MAX Q (KAFB EUL) City TIA Comments April 2, 2020 Letter

Comment	Response	Page
Transit and multi-modal traffic		
Existing Transit and proposed improvements.		
Describe existing transits, expected use of transit and future improvements	Numerous transit routes operate on Gibson, including ABQ Ride Route 16 (Broadway/University/Gibson), Route 96 (Rio Rancho to KAFB), Route 217 (Downtown to KAFB), and Route 222 (Rio Bravo/Sunport/KAFB). There are 10 bus stops on Gibson between Carlisle and San Mateo which are served by Route 16 and Route 222. The Long Range Transit Network in the Connections 2040 Metropolitan Transportation Plan indicates Gibson will function as a Secondary Transit Route, meaning it has 25 minute headway.	10
The development's benefit from improved transit access/schedule and improved transit connection for Kirtland AFB.	The study assumed 2% of the trips would use transit, an estimate considered typical for Albuquerque (pre-COVID). ABQ Ride has historically based their schedules based on actual need and not on studies of projected development. It is assumed that practice would continue, and if additional ridership from this development warrant additional bus stops and/o

CITY OF ALBUQUERQUE PUBLIC WORKS DEPARTMENT ENGINEERING DEVELOPMENT GROUP			
GIBSON BLVD. REHABILITATION/RECONSTRUCTION CARLISLE BLVD. TO JACKSON ST. TYPICAL SECTIONS - EXISTING ROADWAY			
DESIGN REVIEW COMMITTEE	CITY ENGINEER APPROVAL	MO./DAY/YR.	MO./DAY/YR.
DRAWING NO. 4850.90		MAP NO.	SHEET 2-1

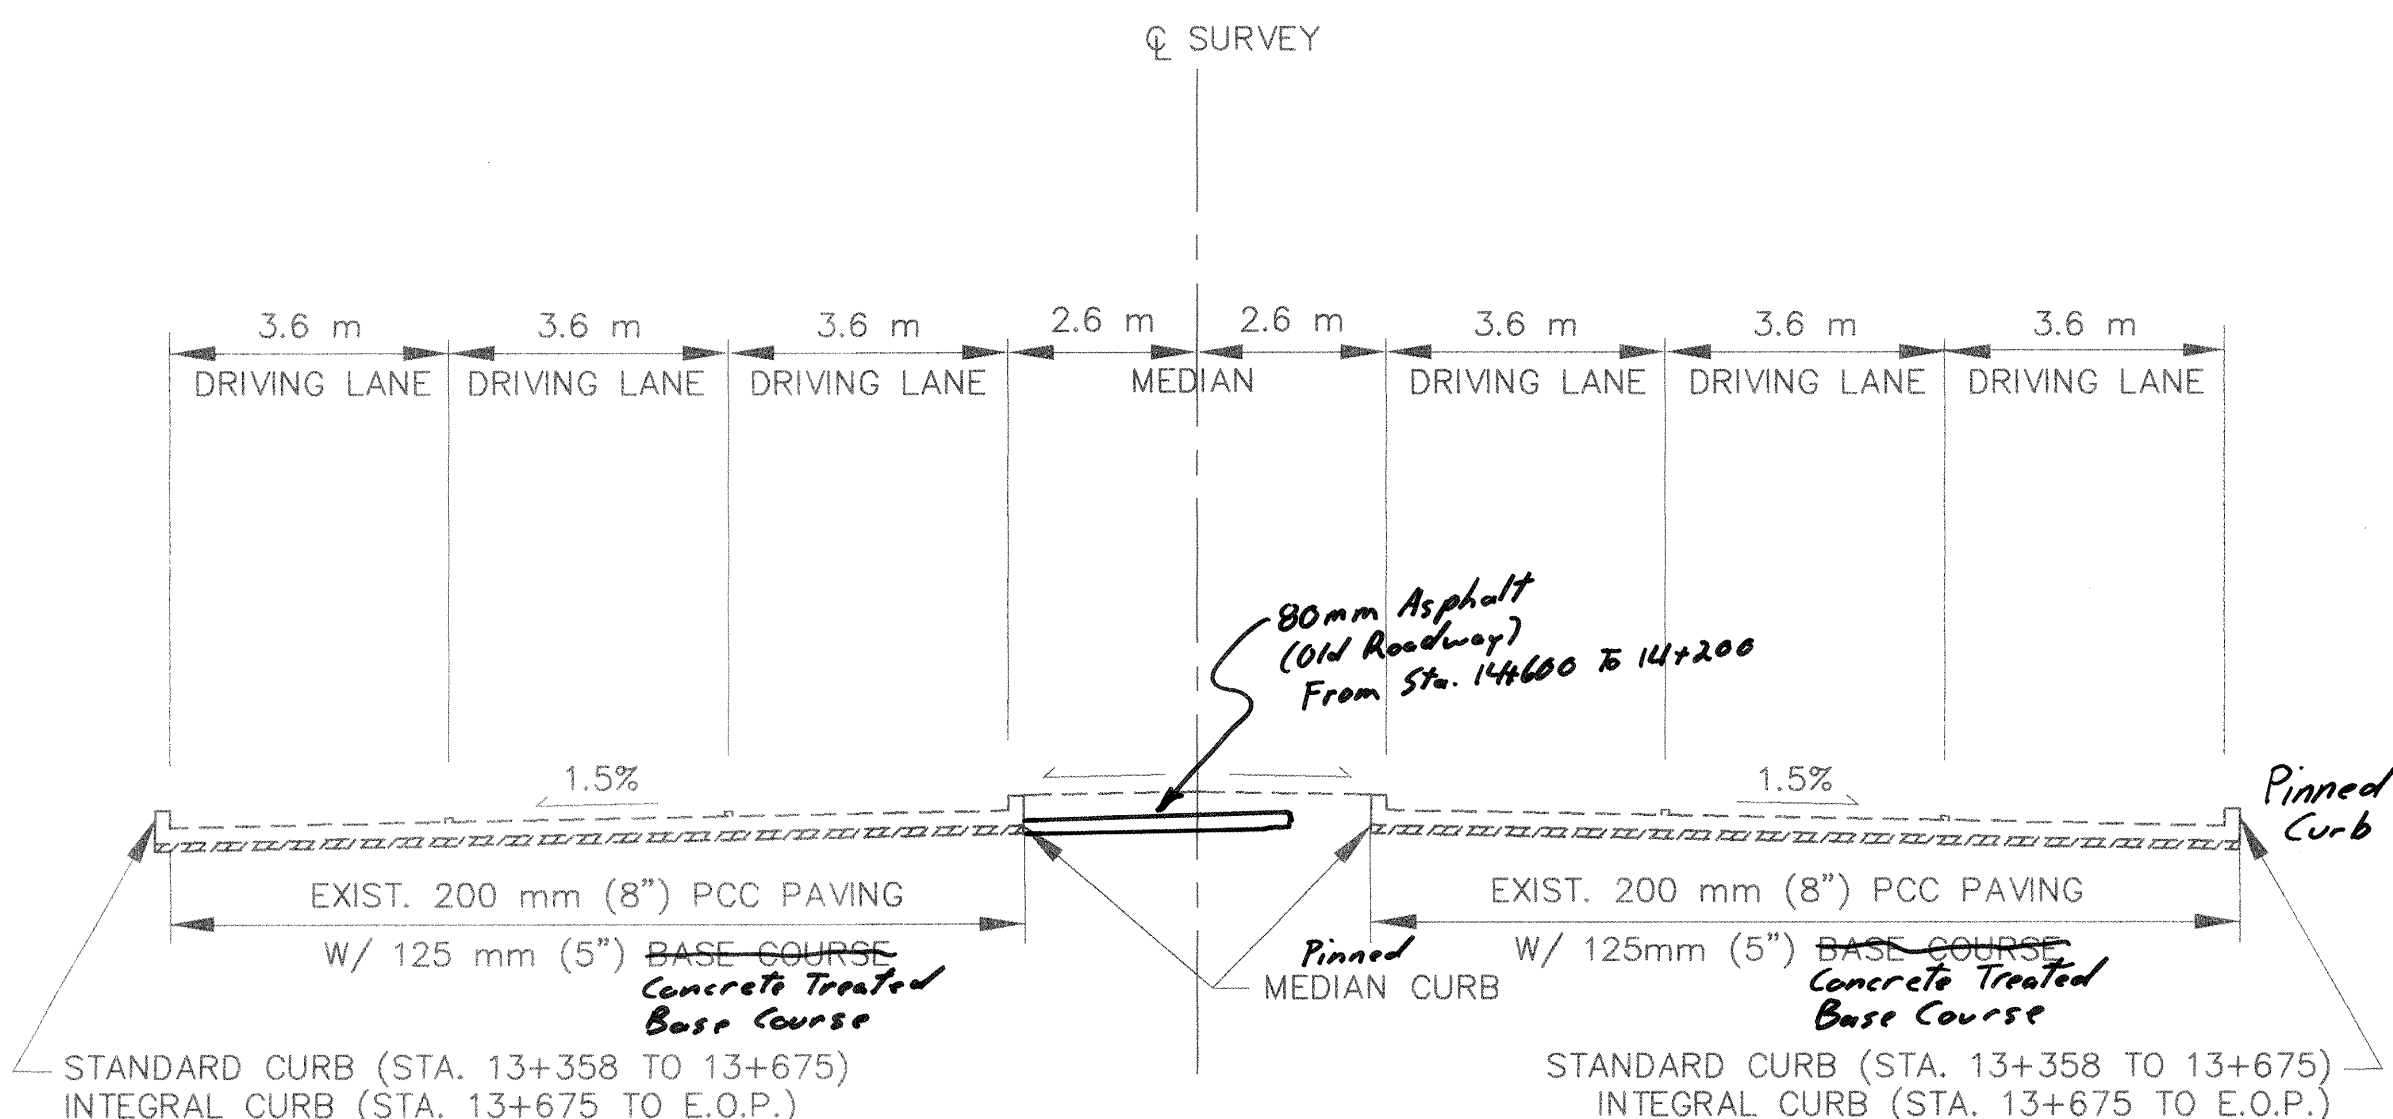
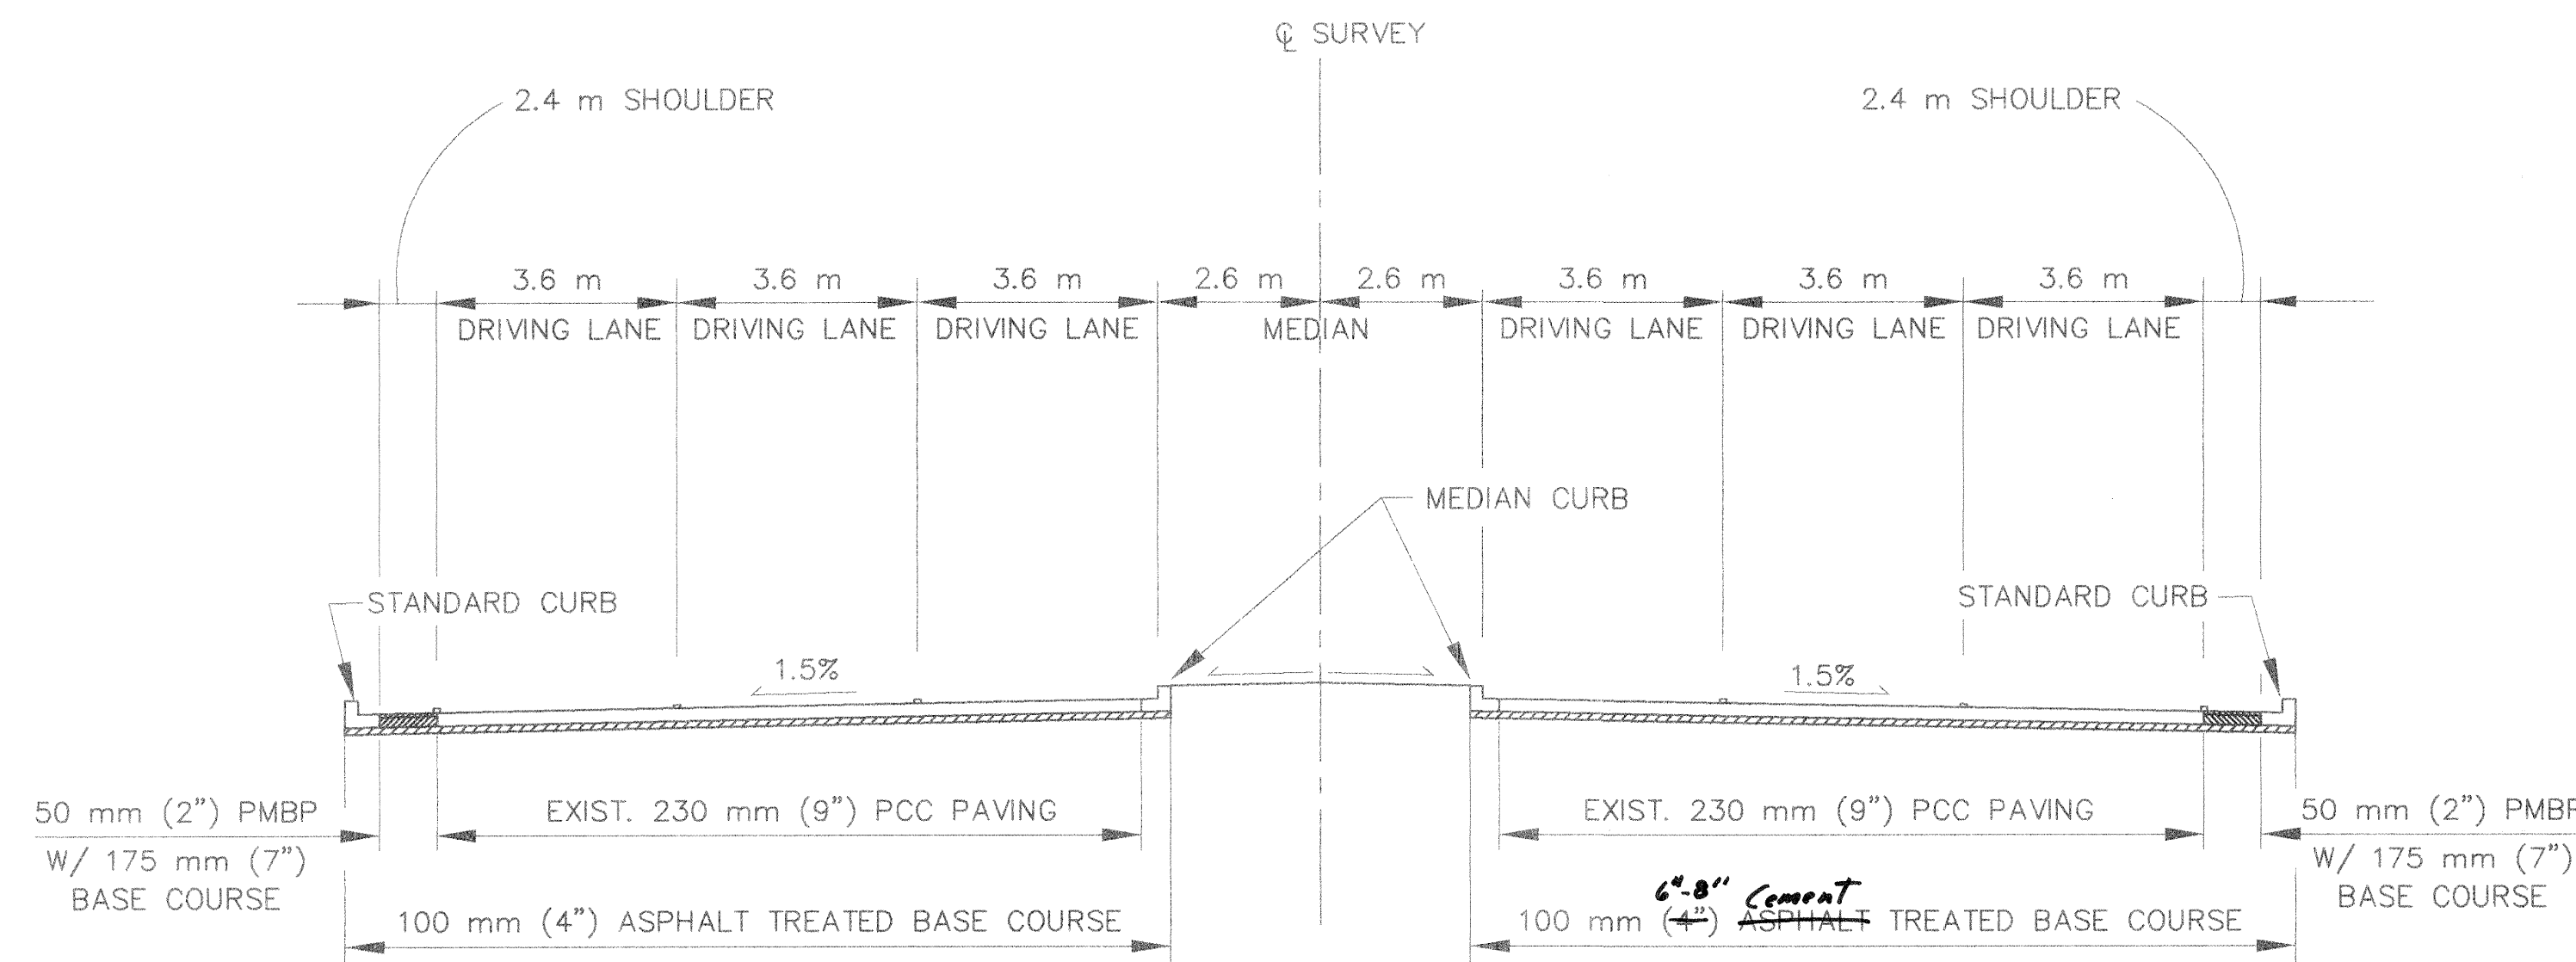
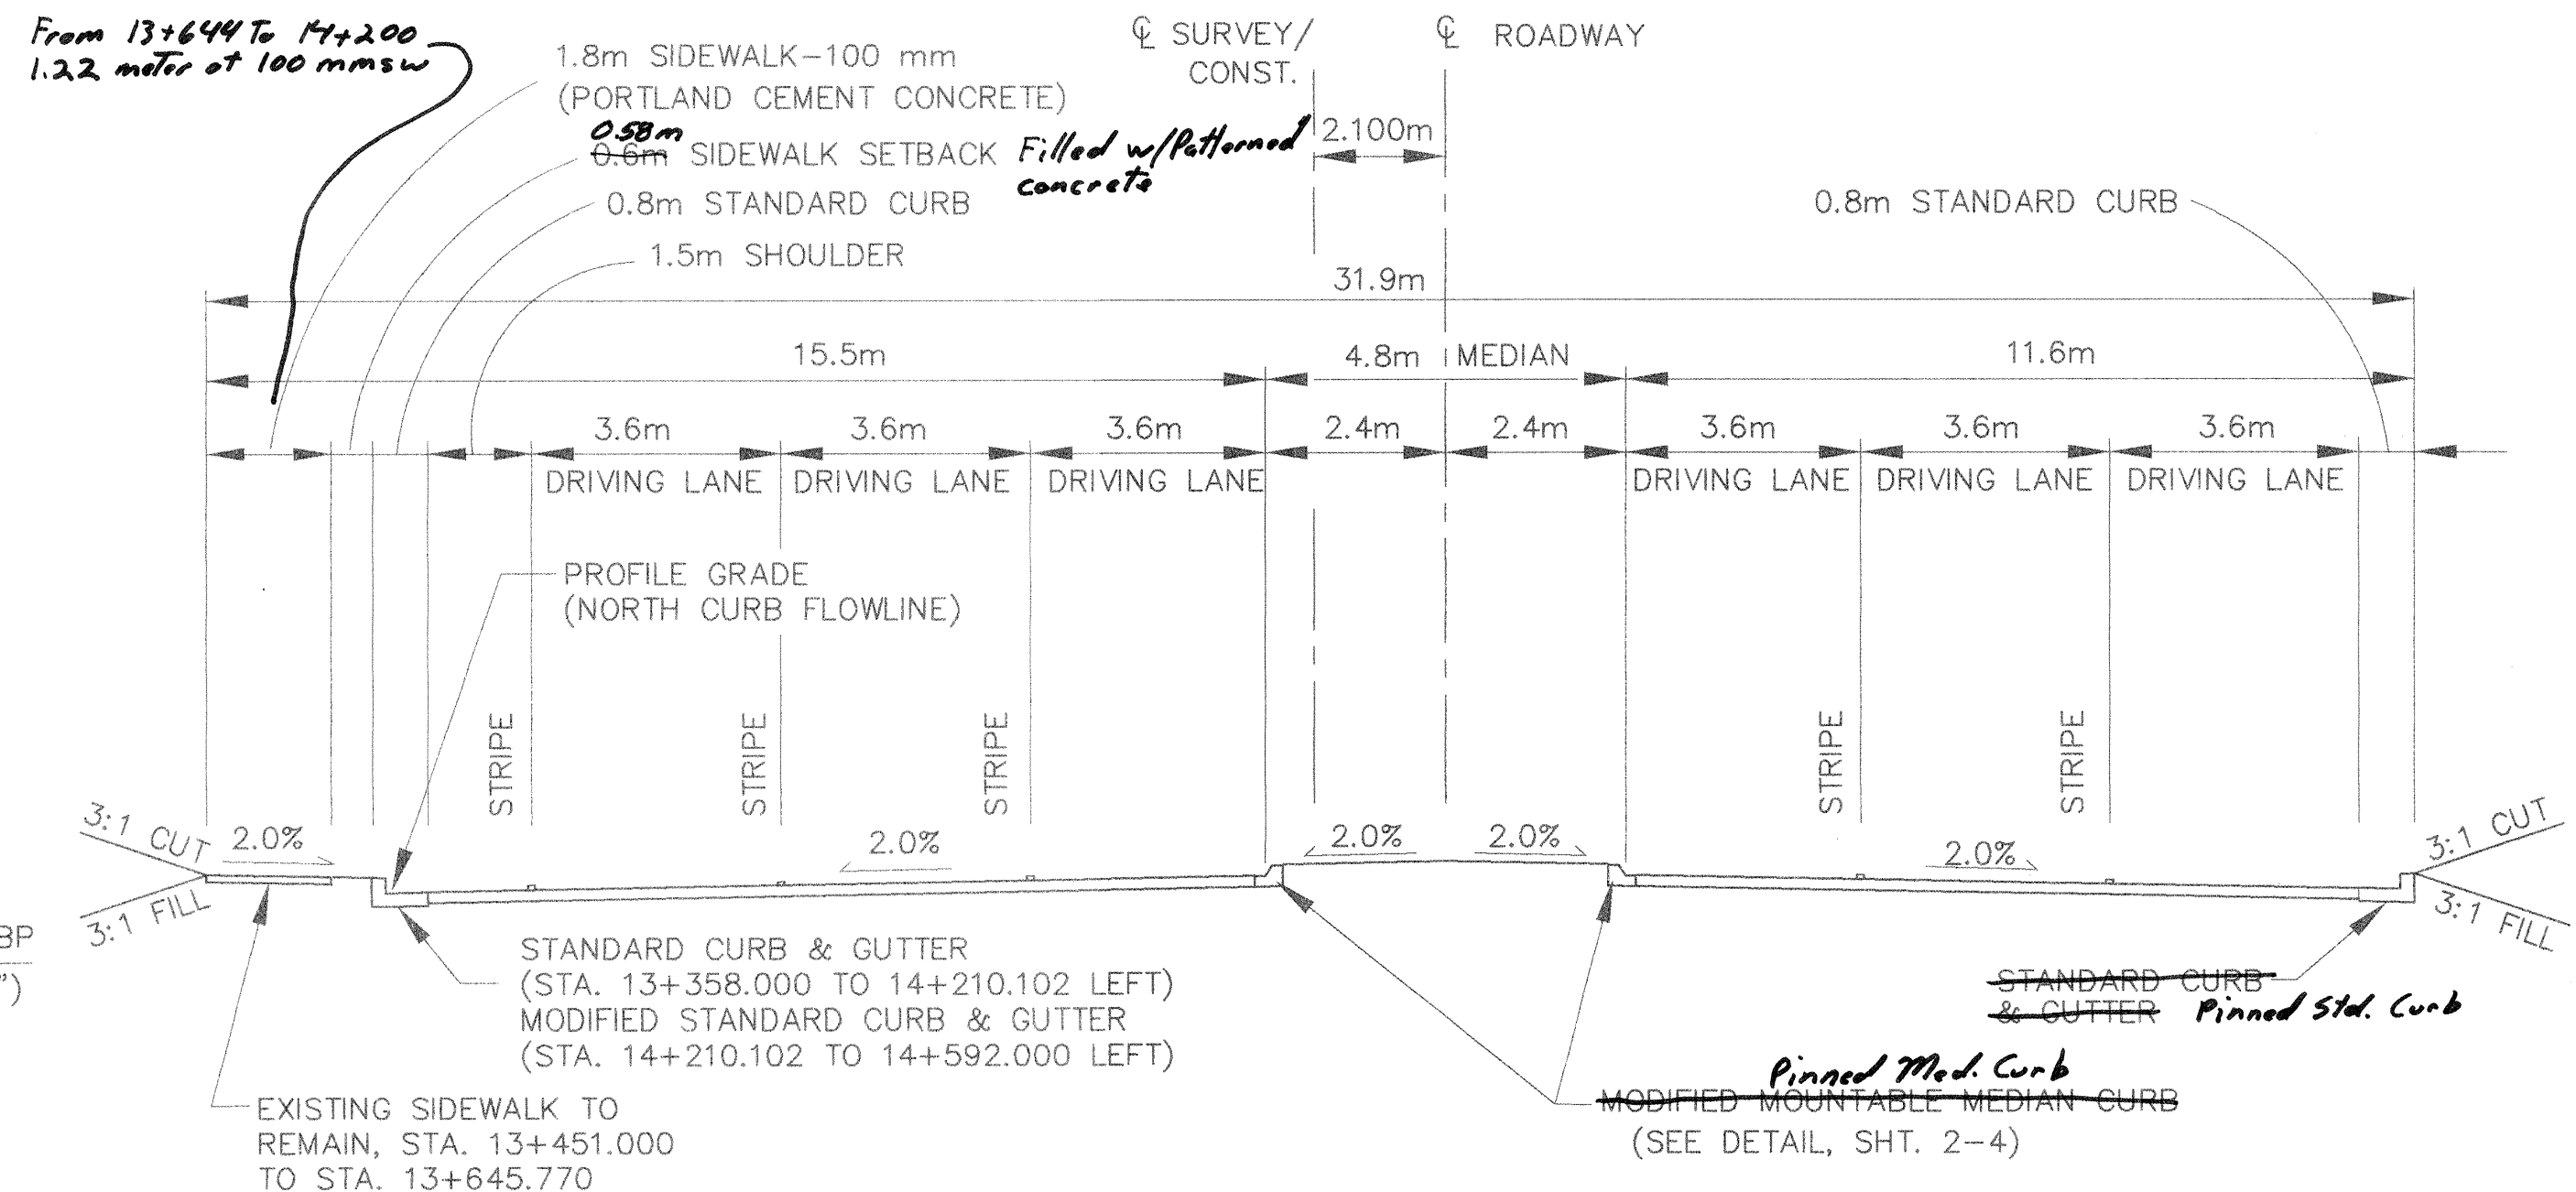
Existing and proposed cross section of Gibson showing existing lane use, widths, medians, sidewalks and multi-use trail.	As-builts provided for a rehab project on Gibson (attached) show roadway envelope and geometry	
Locations for Intersection improvements		
The results of intersection operations in 2030 indicate the following should be evaluated for operation improvements due to the traffic from the proposed development.
